# KITTITAS COUNTY

## DEPARTMENT OF PUBLIC WORKS

### MEMORANDUM

**TO:** All Staff  
**FROM:** Public Works Plan Review Team  
**DATE:** March 27, 2023  
**SUBJECT:** SE-23-00002 PR Douglas

**SITE PLAN  
MULTIPLE PARCELS**

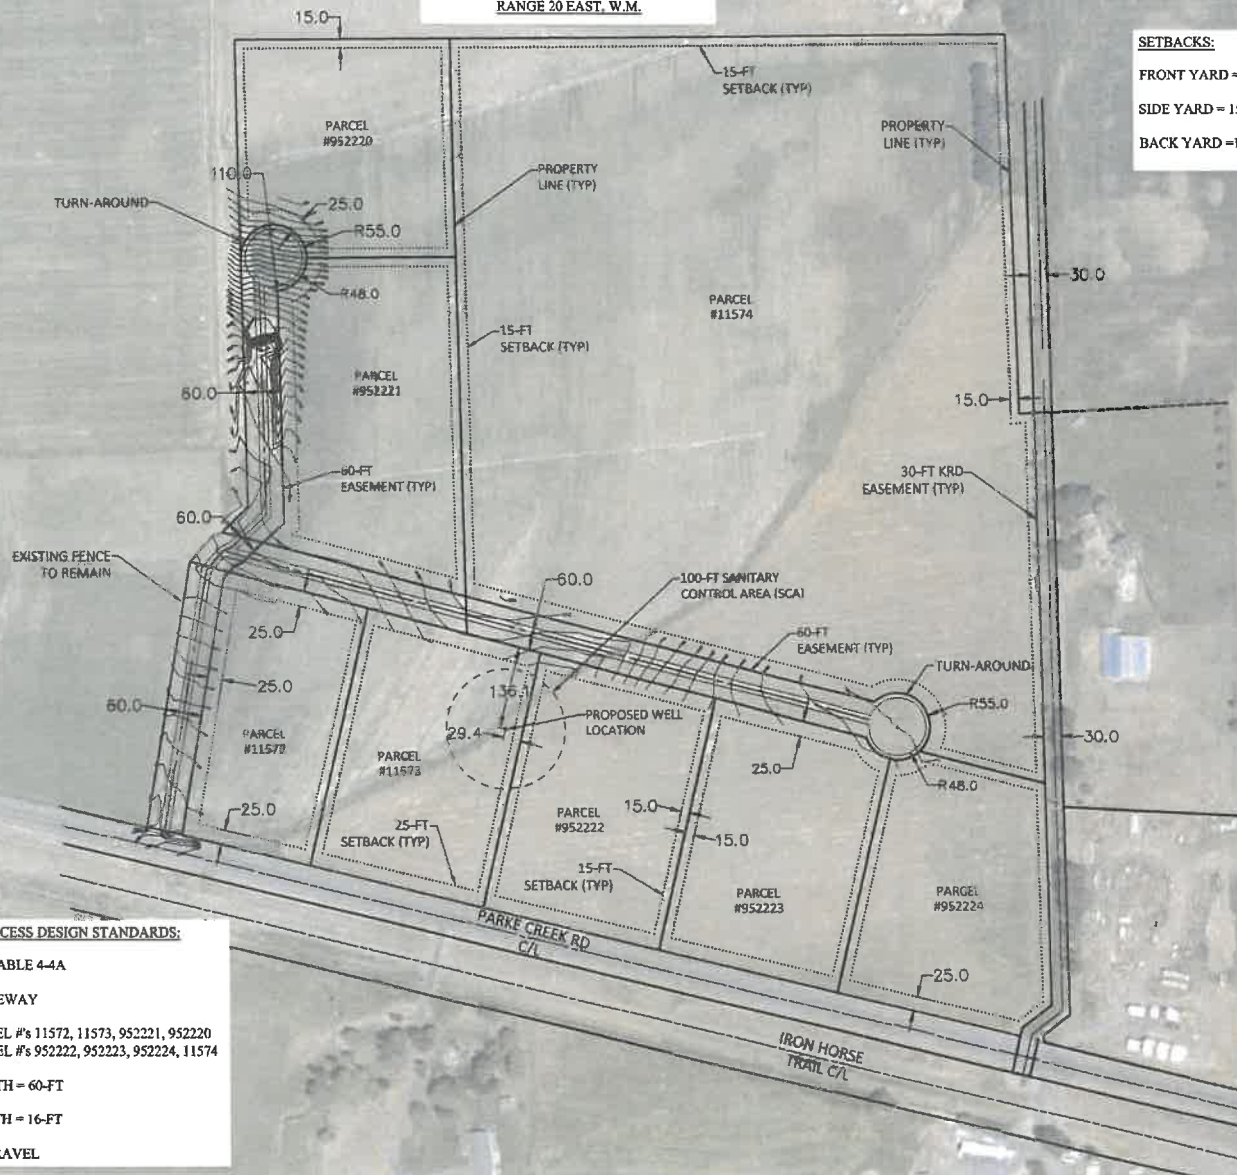
<p><b>ACCESS</b></p>	<ol style="list-style-type: none"> <li>1.) Determine if there is an active/approved access/addressing permit for the parcel for which a SEPA application is submitted. If there is, list the permit number as a comment. Do not include comment b unless there isn't a permit for a driveway.</li> <li>2.) An approved access permit shall be required from the Kittitas County Department of Public Works prior to creating any new driveway access or altering an existing access. Refer to Chapter 12 of the Kittitas County Code for access requirements.</li> <li>3.) Maintenance of driveway approaches shall be the responsibility of the owner whose property they serve. The County will not maintain accesses.</li> <li>4.) In addition to the above-mentioned conditions, all applicable Kittitas County Road Standards apply to this proposal. Access is not guaranteed to any existing or created parcel on this application.</li> </ol>

<p><b>ENGINEERING</b></p>	<ol style="list-style-type: none"> <li>1. Except as exempted in Section KCC 14.05.060, no grading or filling upon a site involving more than one hundred (100) cubic yards shall be performed without a grading permit from the County Engineer or Public Works designee (KCC 14.05.050). An application for grading in excess of five hundred (500) cubic yards shall be accompanied by an engineered grading plan (KCC 14.05.080).</li> <li>2. Traffic Concurrency is required for all land use actions. A transportation impact analysis (TIA) shall be required for all development that will generate more than nine (9) peak hour vehicle trips. Please provide estimated traffic generation for peak hours to determine if a TIA will be required. (KCC 12.10.040(c))</li> </ol> <p><b>AS OF 3/27/2023</b></p> <p><b>Courtesy screening was completed and with information provided, no TIA will be required at this time. (KH)</b></p>
